## KITTTITAS COUNTY COMMUNITY DEVELOPMENT SERVICES

**RE: Mildon Short Plat (SP-07-81)**

Kittitas County Community Development Services has determined that the Mildon Short Plat (SP-07-81) is a complete application and hereby grants **conditional preliminary approval** subject to the following conditions:

MILDON SHORT PLAT
 PART OF SECTION 12, T. 17 N., R. 17 E., W.M.
 KITTITAS COUNTY, WASHINGTON

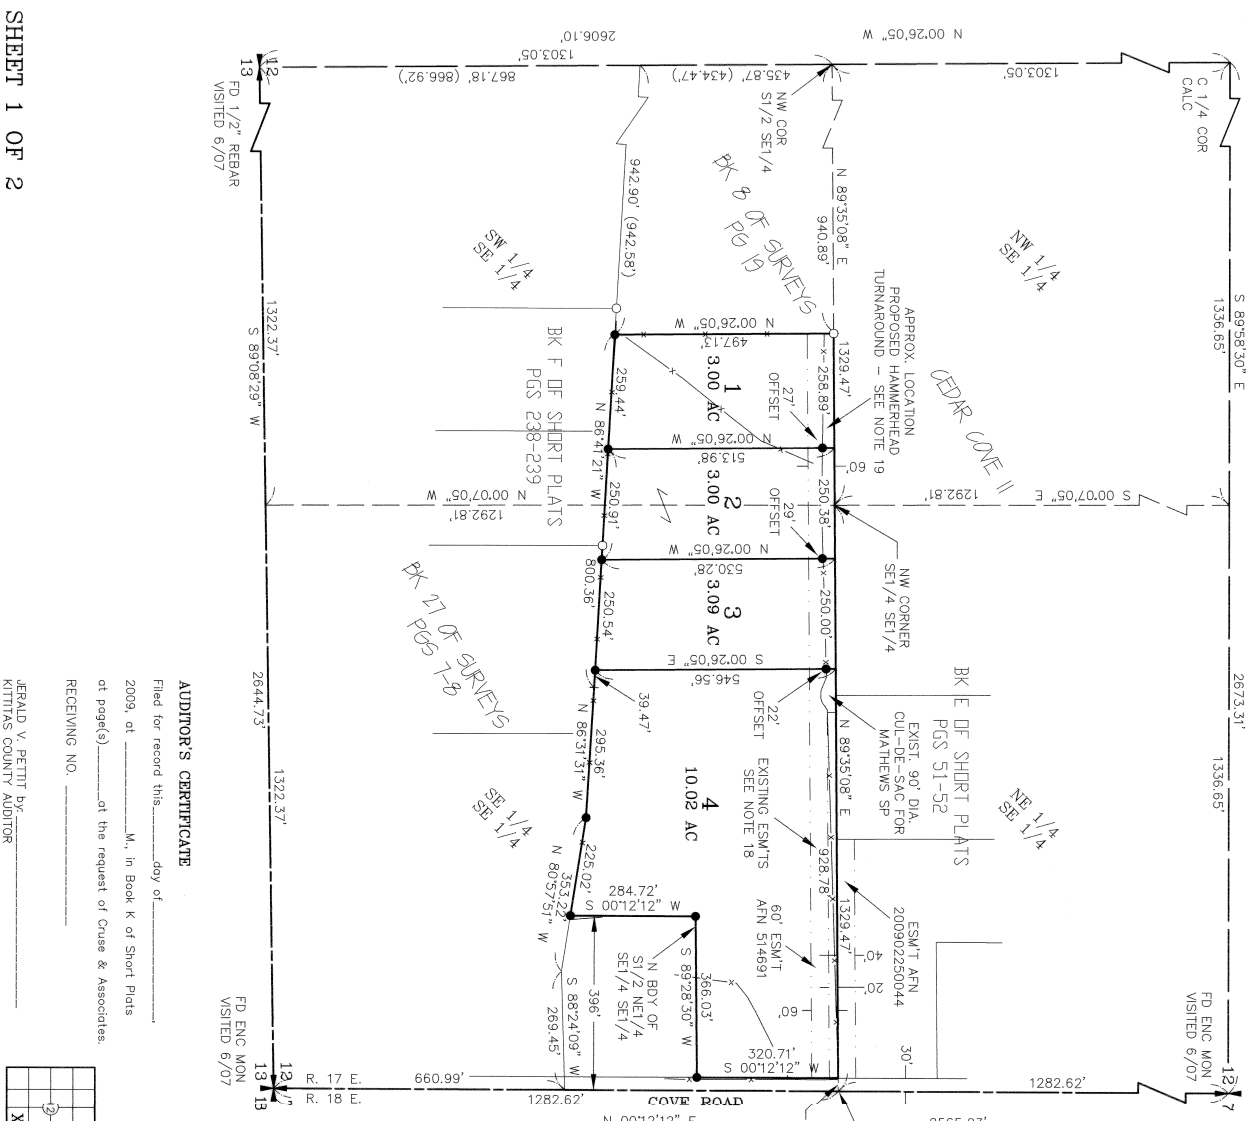
- 1) Both sheets of the final mylars shall reflect short plat number SP-07-81.
- 2) Full year's taxes must be paid for 2007 on all tax parcel numbers per requirement of the Kittitas County Treasurer's Office.

- 3) **Legal Description:** The legal description, as described on the preliminary short plat blueline, does not match the legal description provided in the subdivision guarantee. The last paragraph of the legal description begins with, "And except that portion of the south half of the *northeast* corner..." The legal description provided in the subdivision guarantee states, "And except that portion of the south half of the *southeast* corner..." An accurate legal description shall be required on the face of the final plat and there shall be no discrepancies.
